Response by Michael Brown to Action Point no. 2 from Open Floor Hearing 1.

Examples of inadequate assessments, and factors leading to significant under assessments in the LVIA in the ES Chapter 8 (APP-045 for the Central site – paragraphs 8.9.178 – 8.9.231), include:

Representative Viewpoint 37a: View looking east from footpath 152/6/10 at east bank of River Evenlode

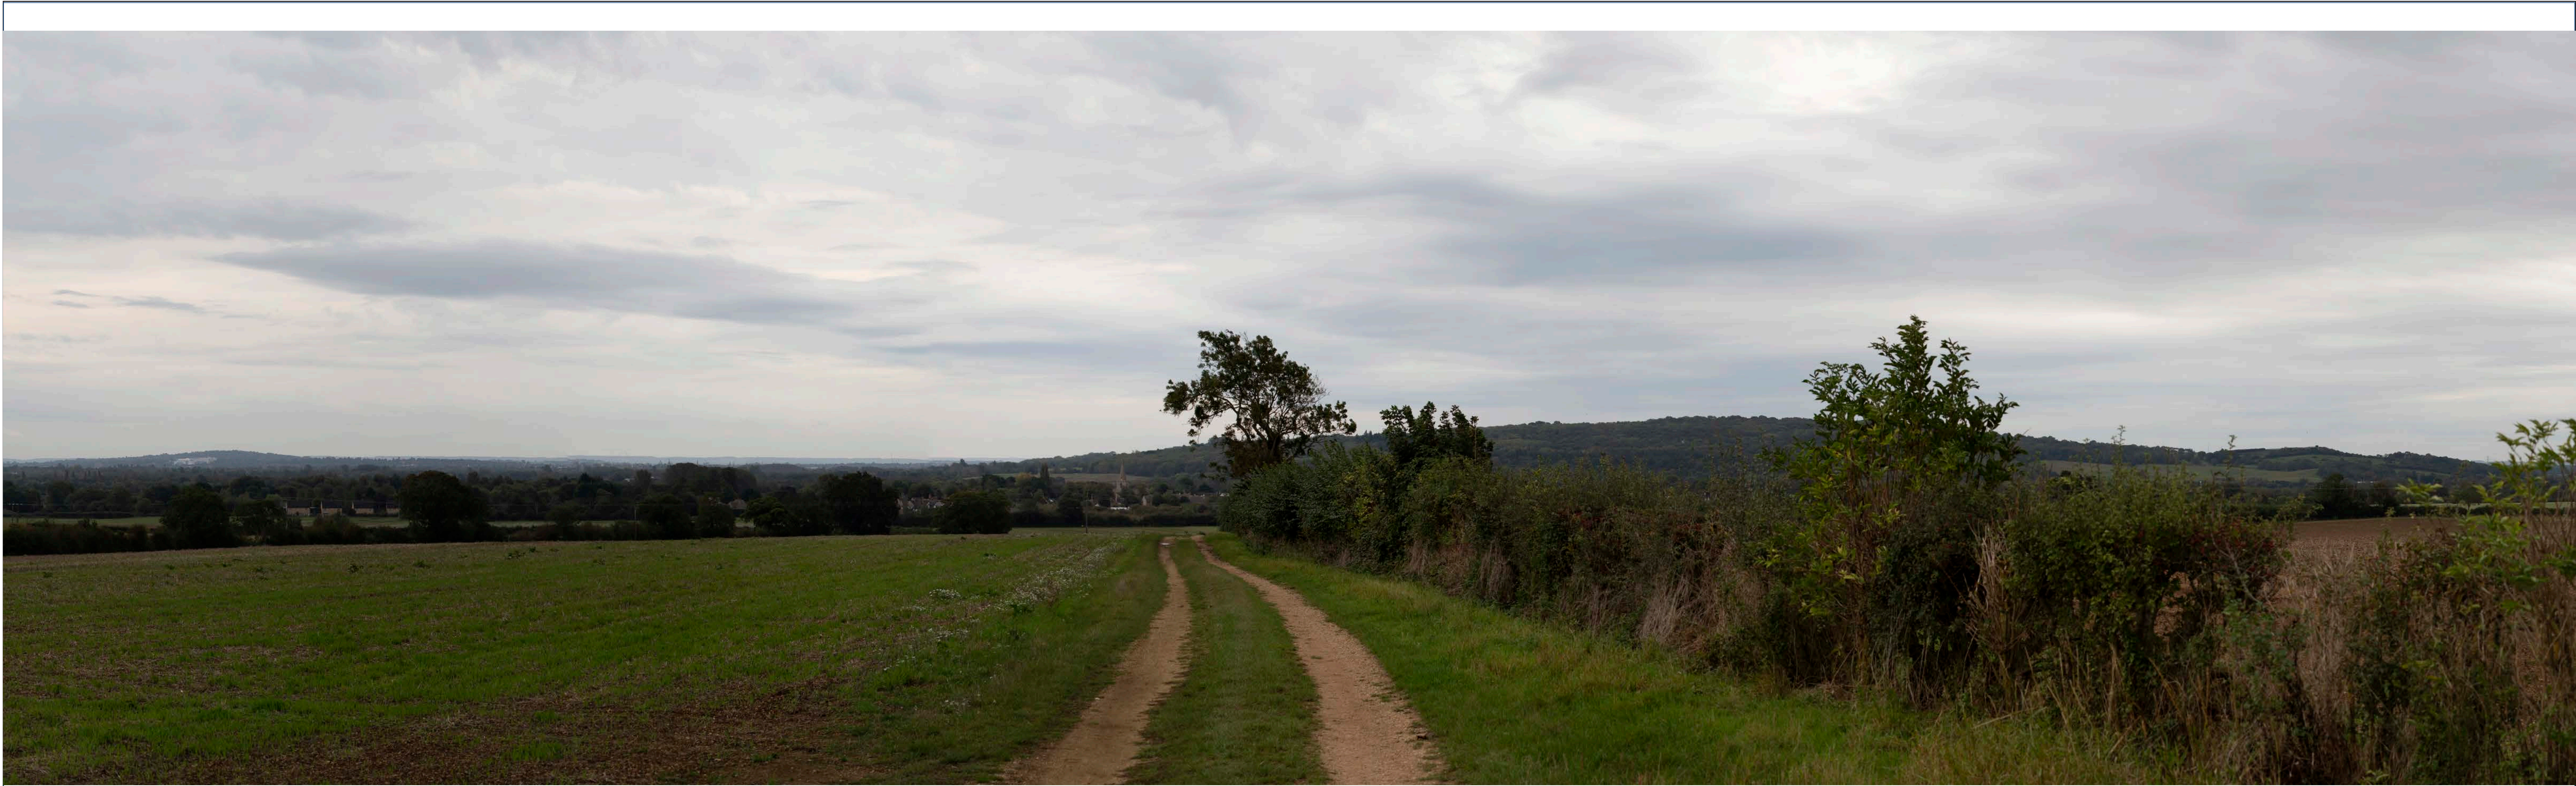
2. The failure to provide photomontages for all current viewpoints, in particular: 21, 22, 24, 26, 33, 37a and 39 in the central site has exacerbated the problem. Viewpoint 24 for example provides a major view across the Evenlode valley. (APP-065, Fig. 8.178 summer and APP-066, Fig. 8.62 winter). It will be seriously impacted by fencing and panels. It is not, as claimed, 'a glimpsed view' (APP-045 at paragraph 8.9.195) but a well-known and admired stopping point for the panoramic view across the valley.
